**Subject:** RE: A/110/20/RES Land South of Water Lane Angmering Ap/17/OUT for the Bridge over the Black Ditch providing access to the approved development.

With regard to Planning Application A/110/20/RES further information has become available since I submitted my representations.

The EYA 2018 report contains 24 maps titled Case A, which is pre-development and Case-B, which is post development.

Figure 3.18: Case-A: Pre-development, level map 0.1% AEP

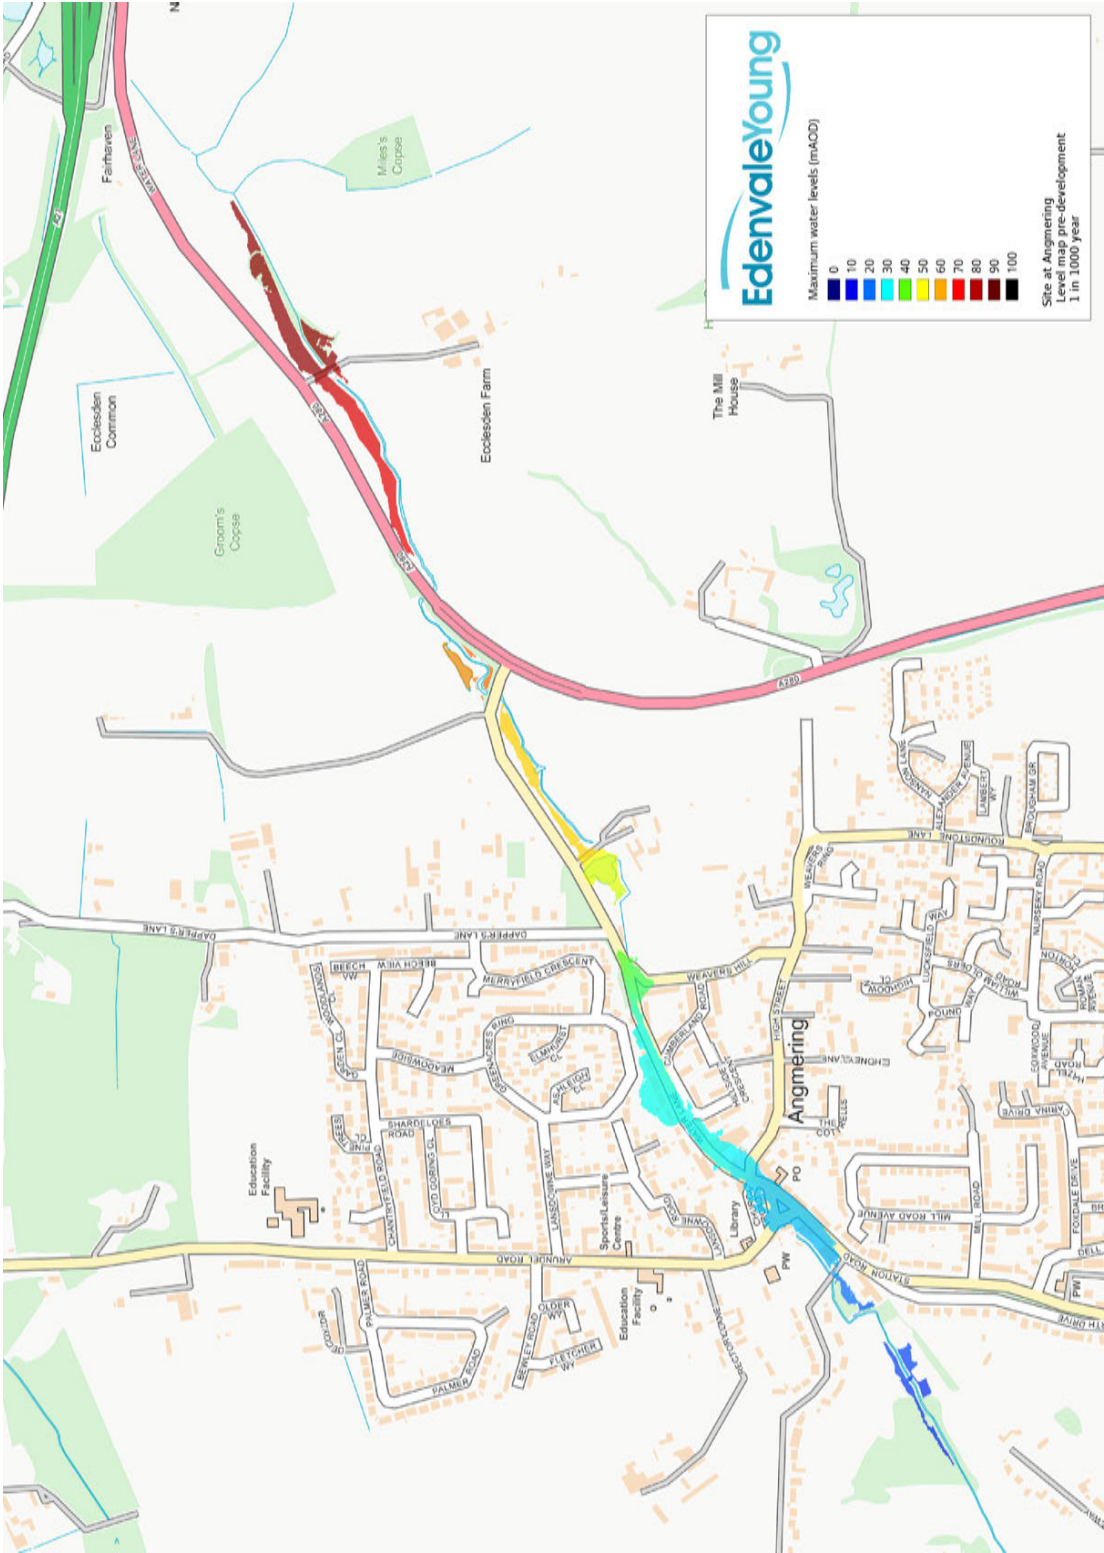
For example, the key to both the Case-A and Case-B level maps that describes 'Maximum water levels (mAOD)', and upstream of the Ecclesden Farm access the level is colour coded medium red corresponding to 80 metres AOD on the key, when we know that the top of Highdown is 81 metres AOD.

3.2.2 Case-B: Post-development

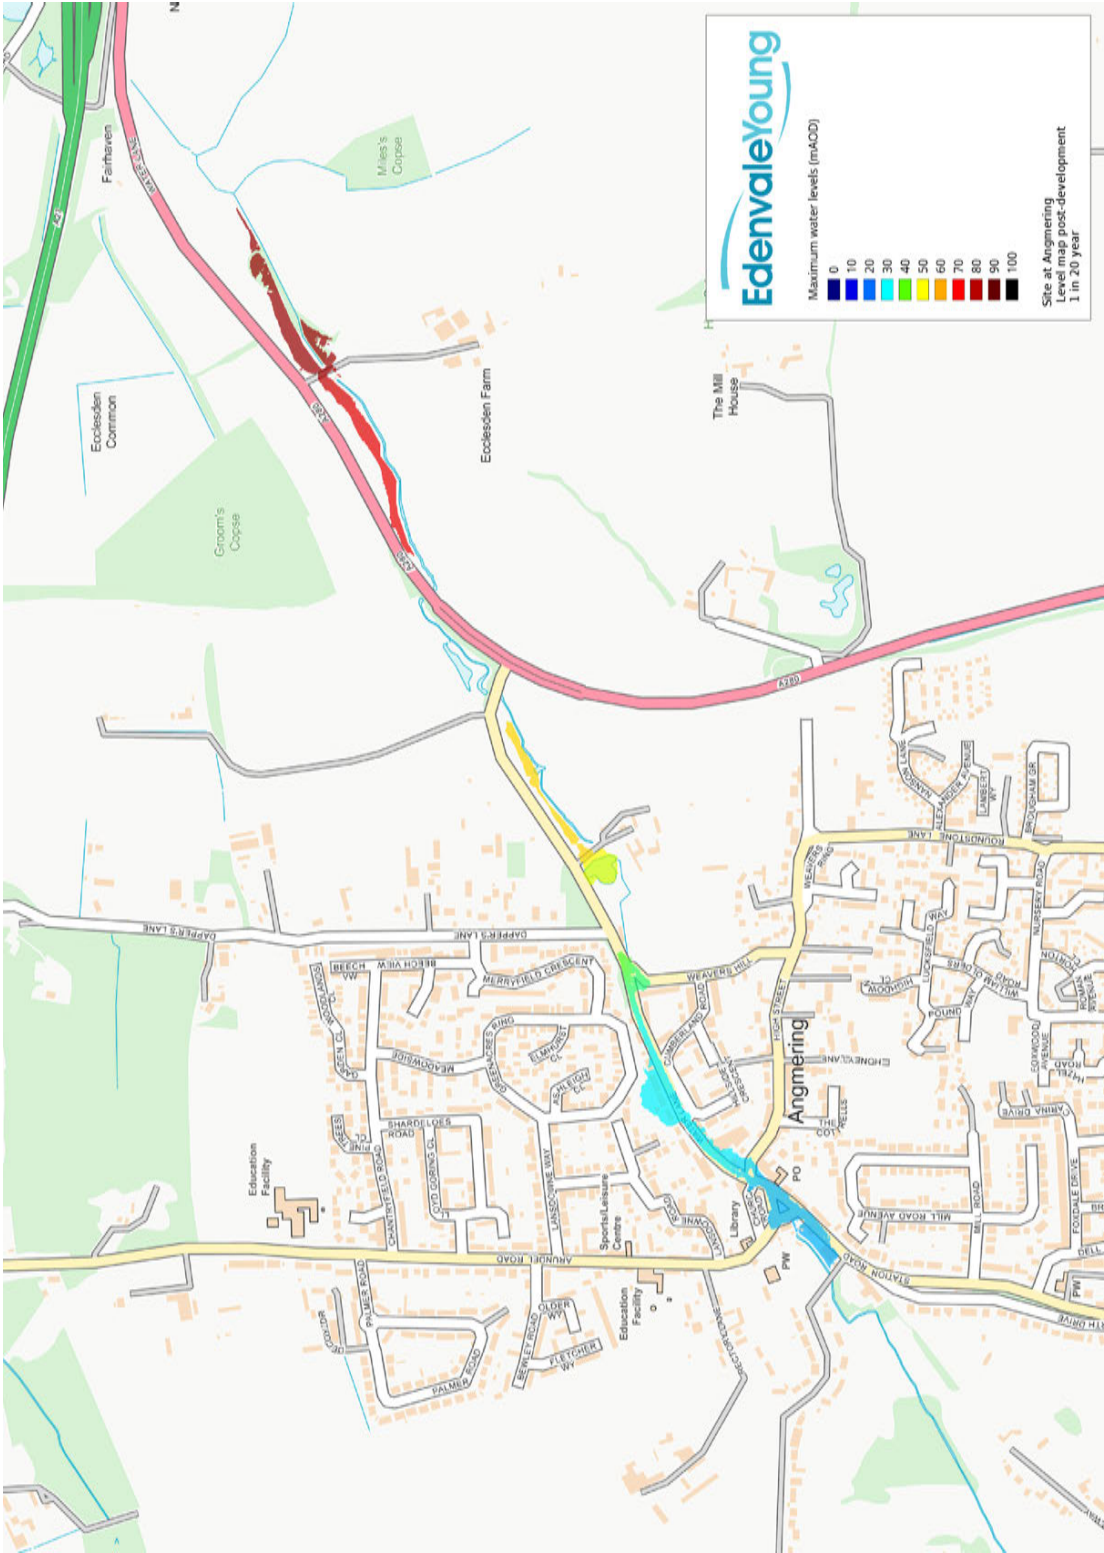
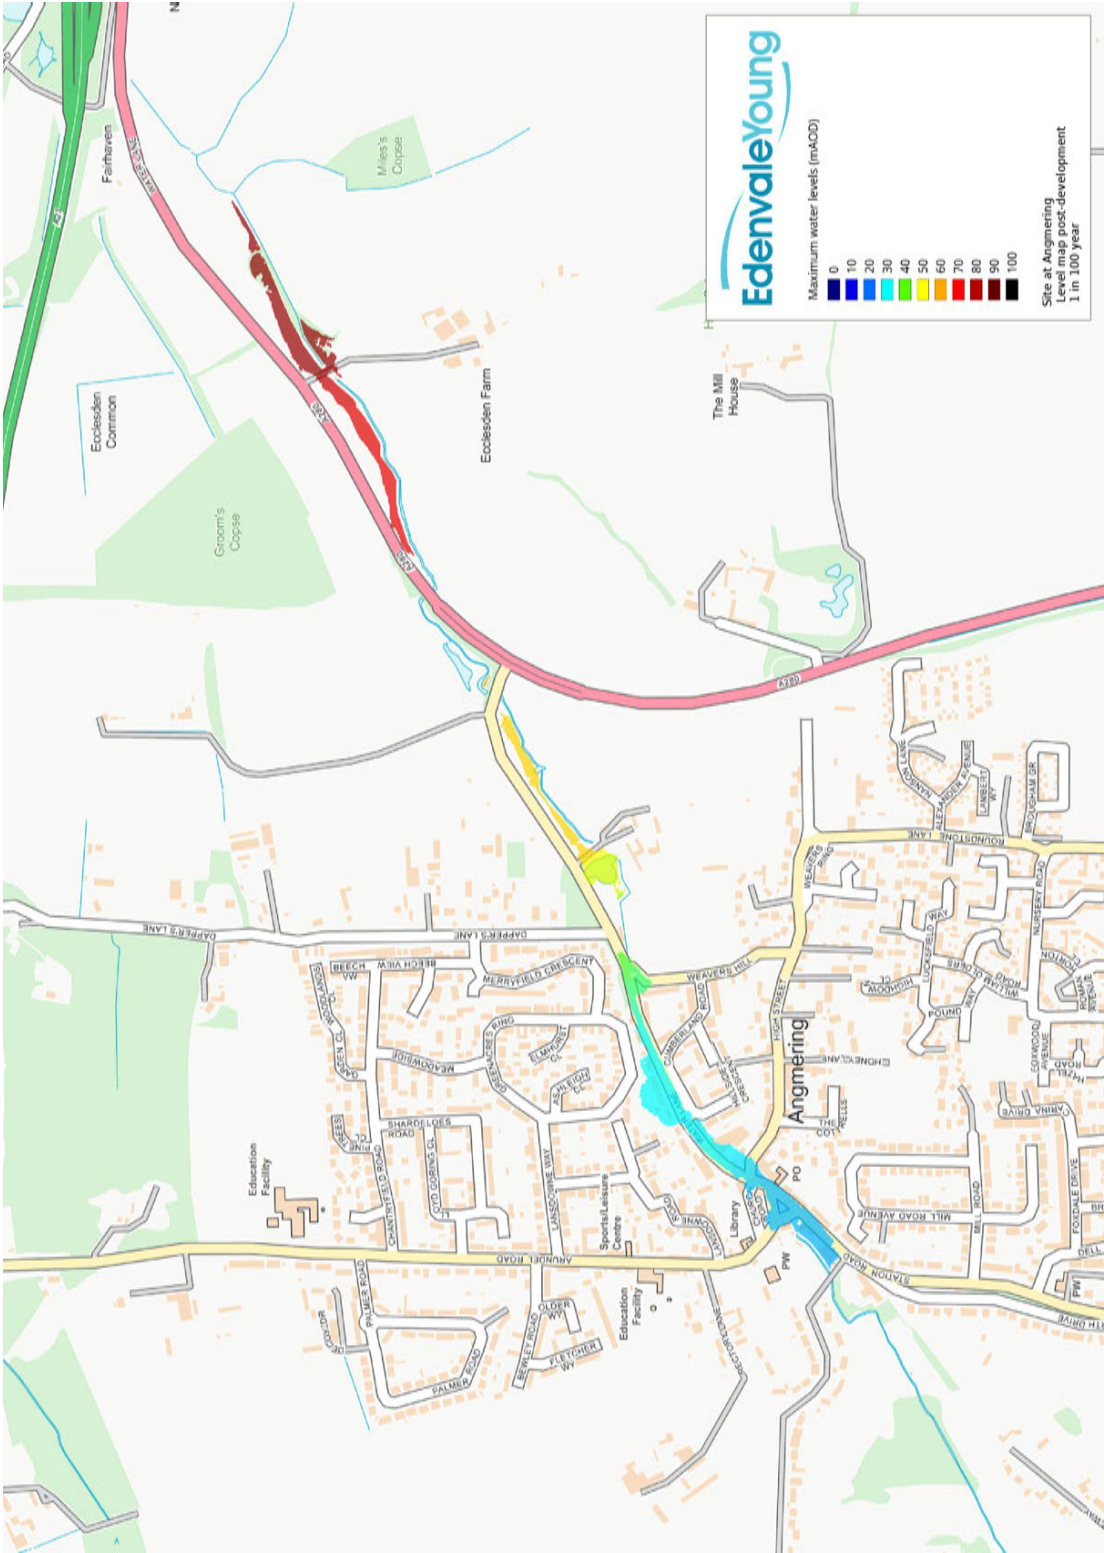
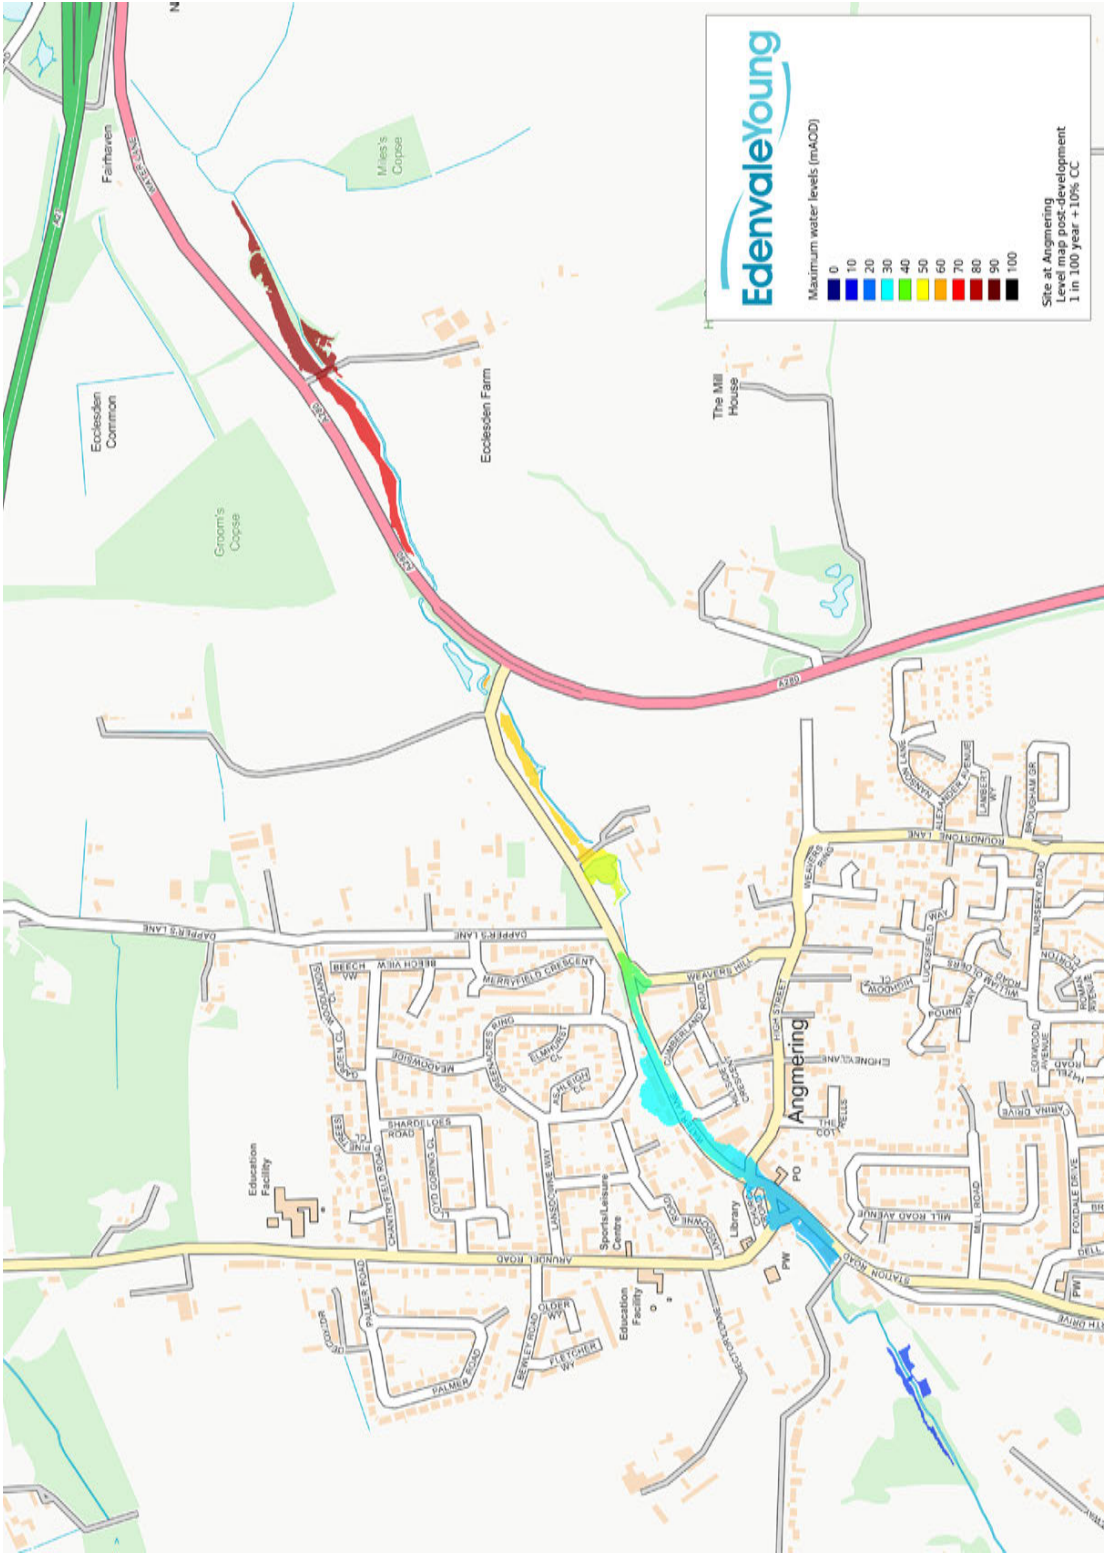
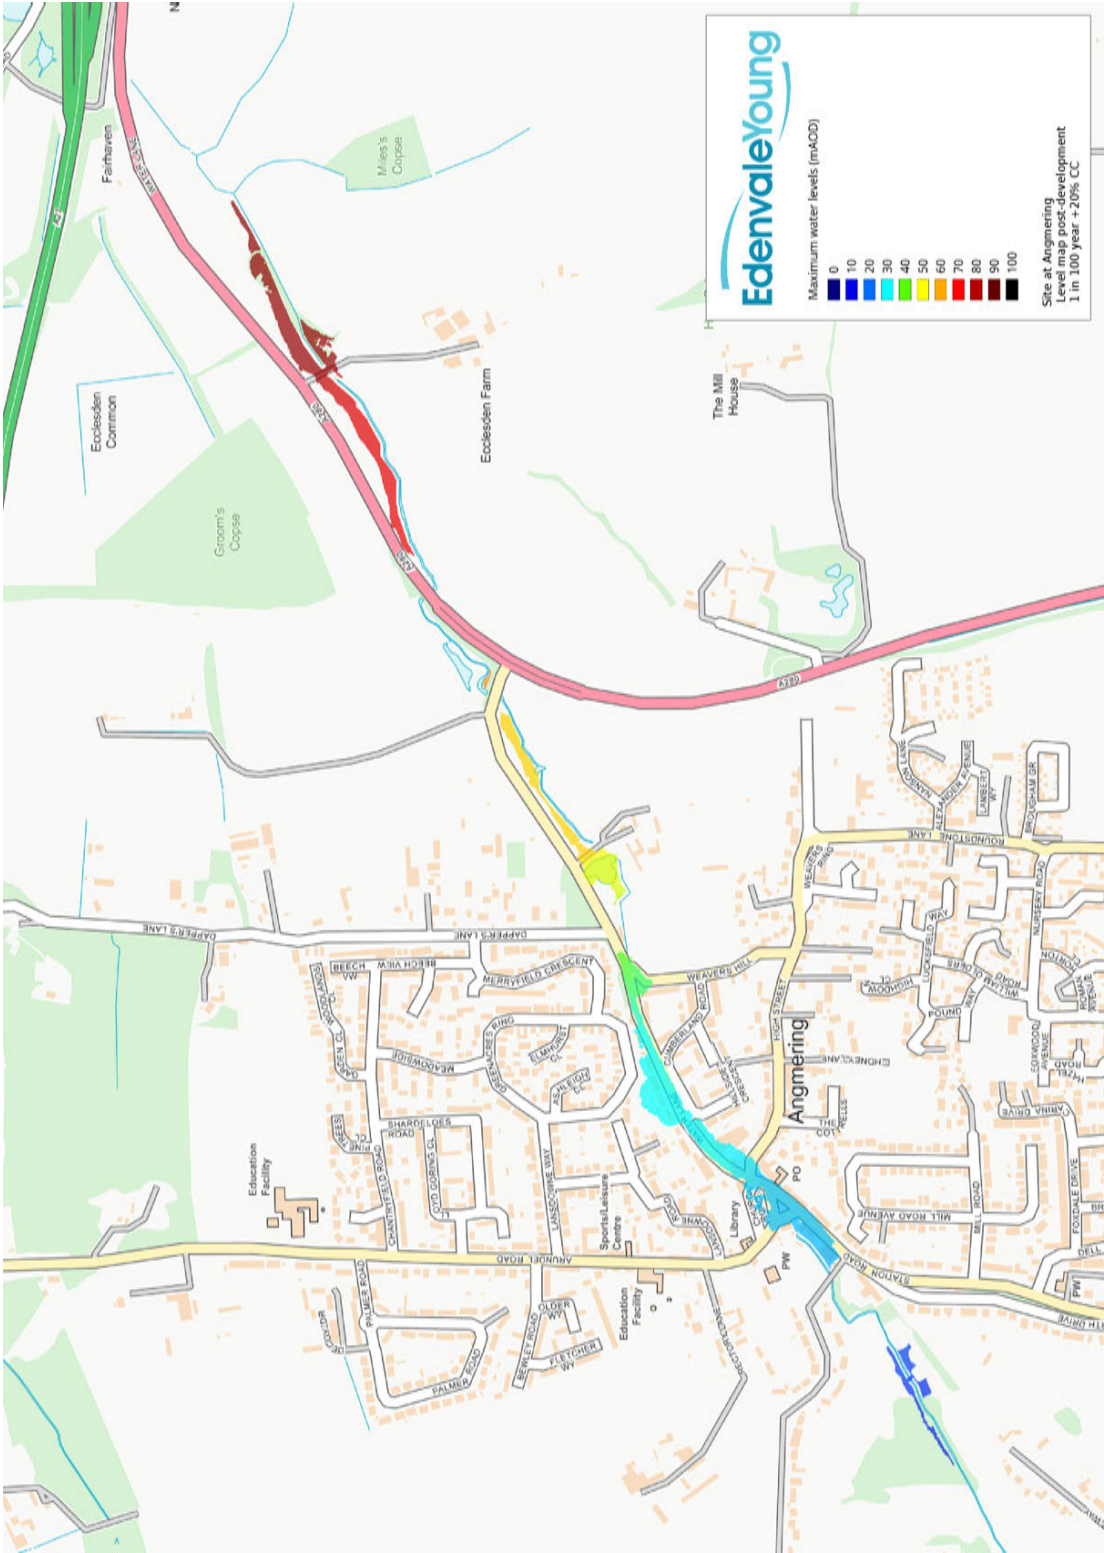
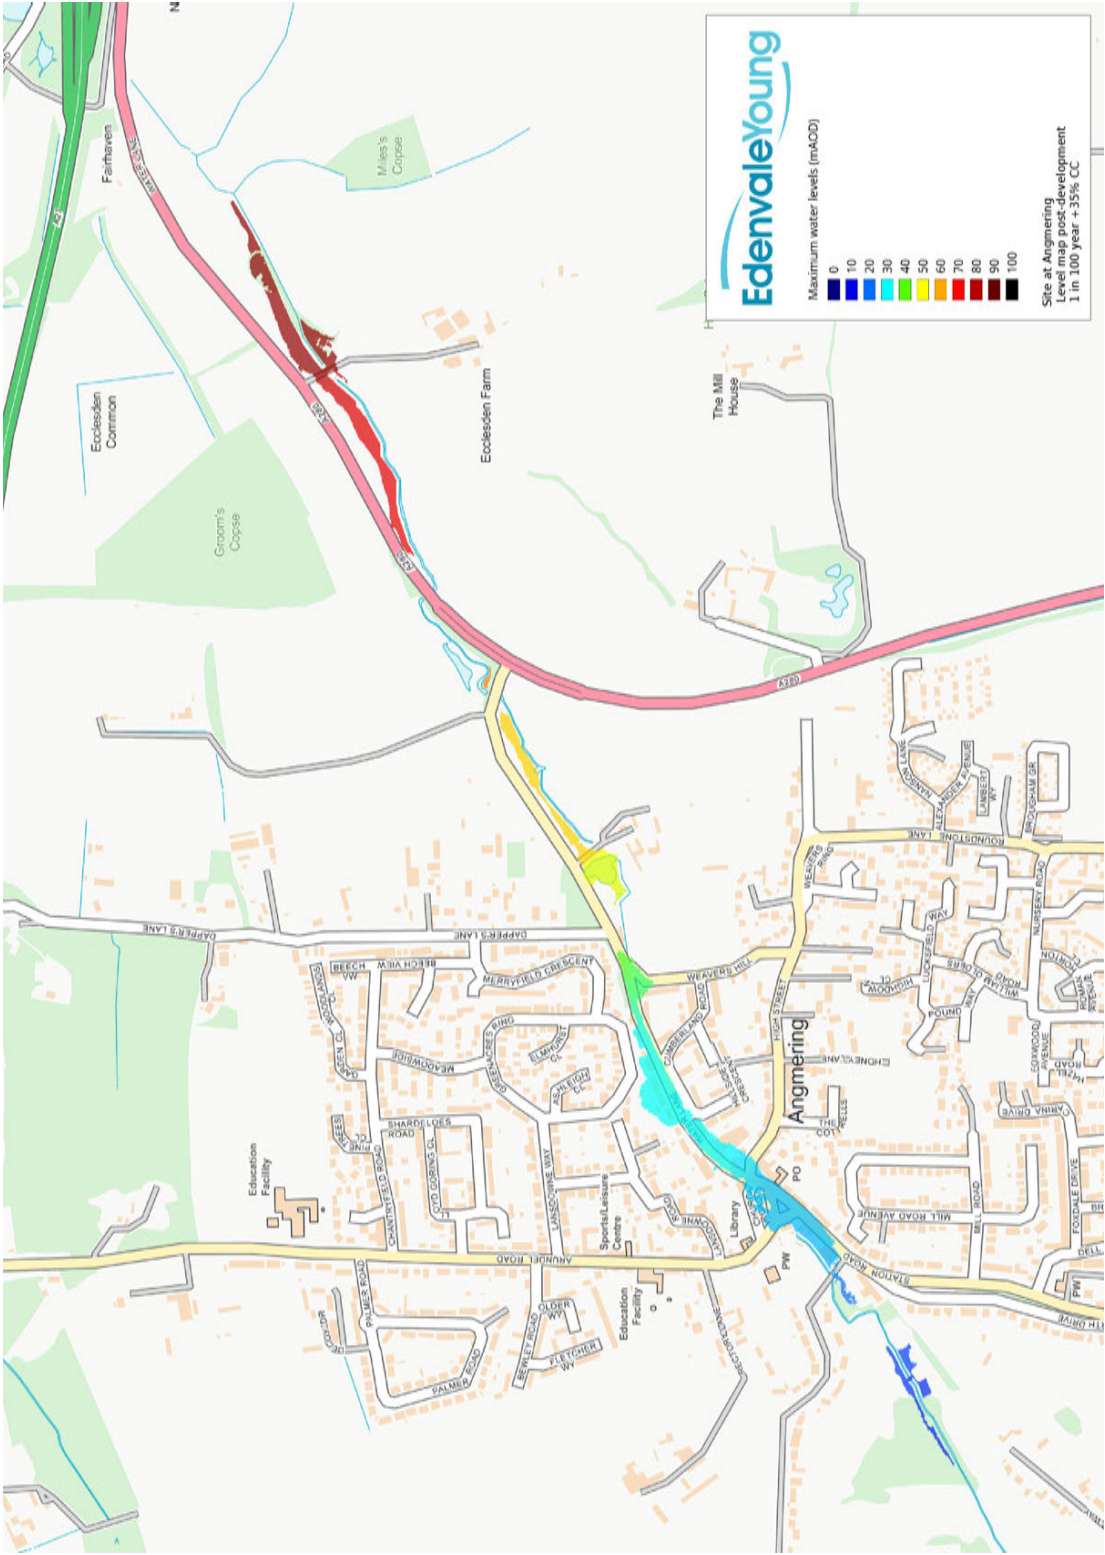
- The case B depth maps numbered 3.7 to 3.12 are headed 'Pre-development' when it seems they should be 'Post-development'.
- The case B level maps numbered 3.19 to 3.24 are also headed 'Pre-development' when it seems they should be 'Post-development'.
